From: Sue Howell
Sent: 14 August 2019 16:04
To: Planning.Responses <Planning.Responses@arun.gov.uk>
Cc: David Easton <David.Easton@arun.gov.uk>
Subject: RE: Planning Consultation on: BE/37/19/PL

Comment from Greenspace

APPLICATION NO: BE/37/19/PL

Description of Works: Erection of 99 No. dwellings together with landscaping, open space & associated works. Access to be taken from New Barn Lane (alternative scheme to BE/29/19/PL).

Tree Pit Detail: Soft Landscape

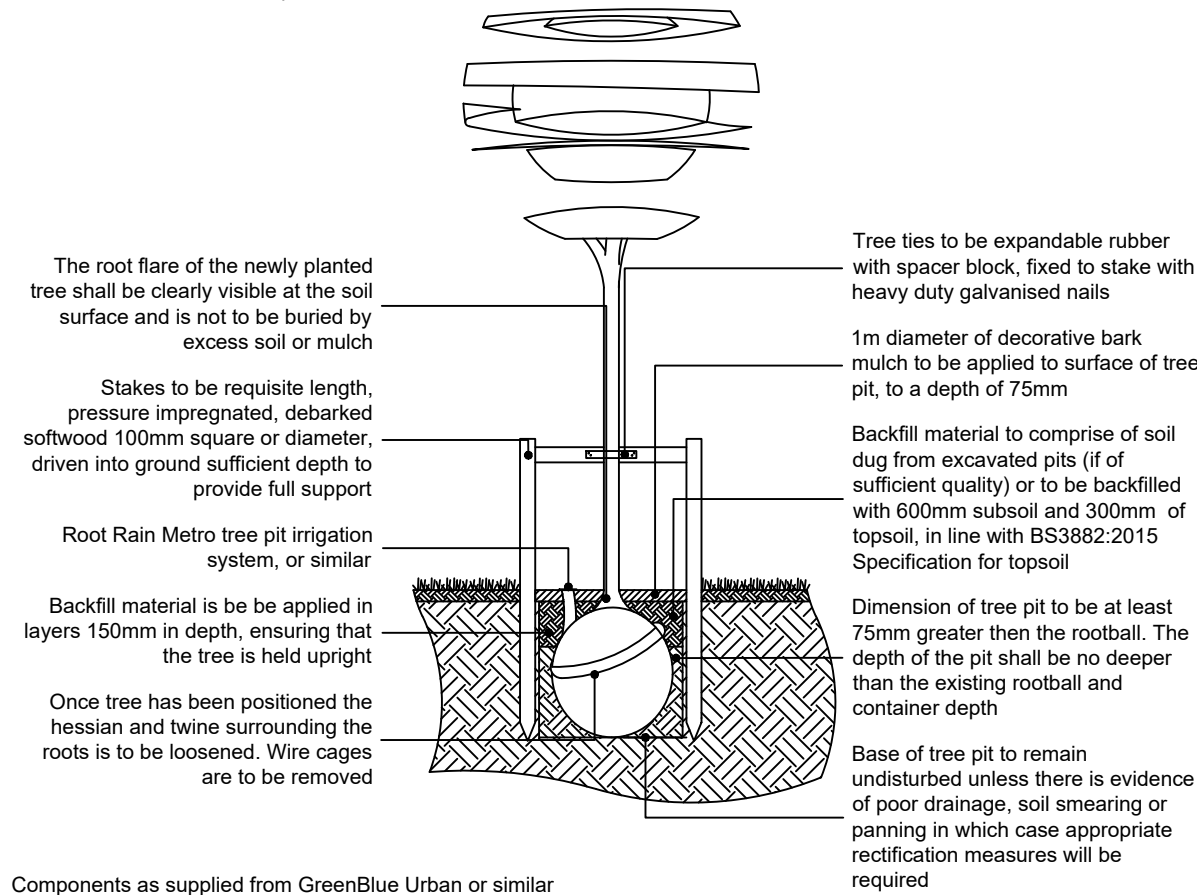
The landscape information contained within landscape proposals LIN22251 11D Sheets 1-6 is detailed and provided in sufficient detail re species choice, quantities, planting densities and size at time of planting. I am pleased to see that detail has been proposed for the tree pit formation with the incorporation of tree support components such as those supplied by GreenBlue Urban or similar. With the employment of such systems and adequate aftercare support the trees should be given a good chance to establish and flourish. It is encouraging to see the specification of root barriers where there are trees in conjunction with SuDS features, these are to be encouraged and should be beneficial in the long term establishment reducing root inclusion conflict.
